[REDACTED]  
Sent: 07 February 2012 09:41  
To: Planning  
Subject: Welwyn Hatfield Council Online Planning - Comment

Application Number: S6/2011/2816/FP

Address: 7 Park Street  
Old Hatfield  
AL9 5AT

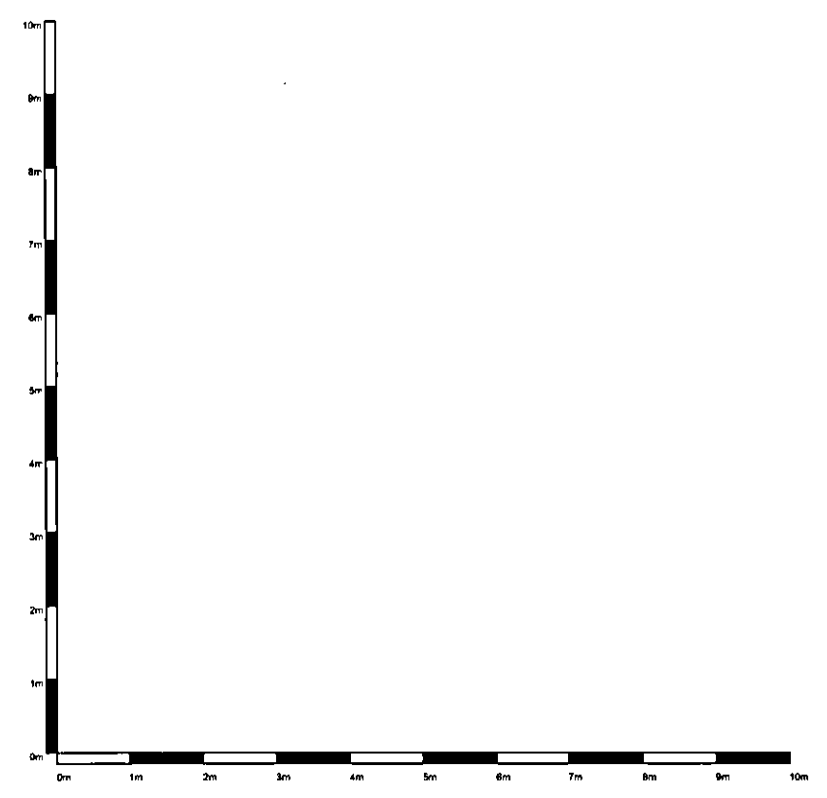
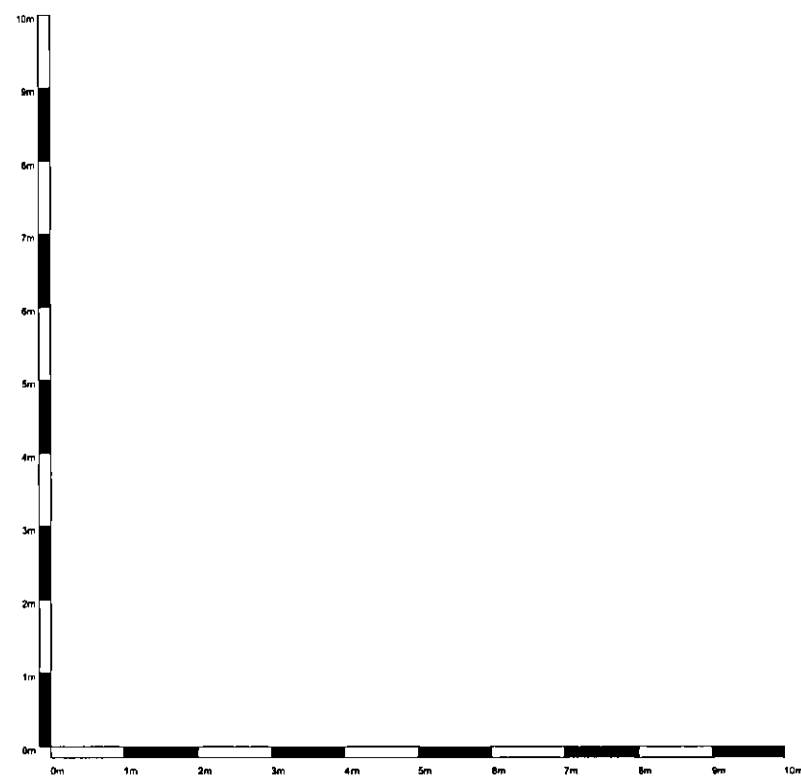
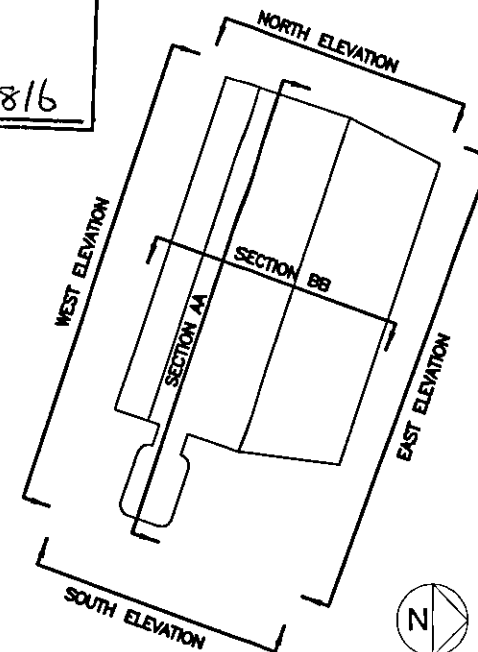
Comment: This development causes further large plain elevations to overlook a listed building, damaging the setting of the building.
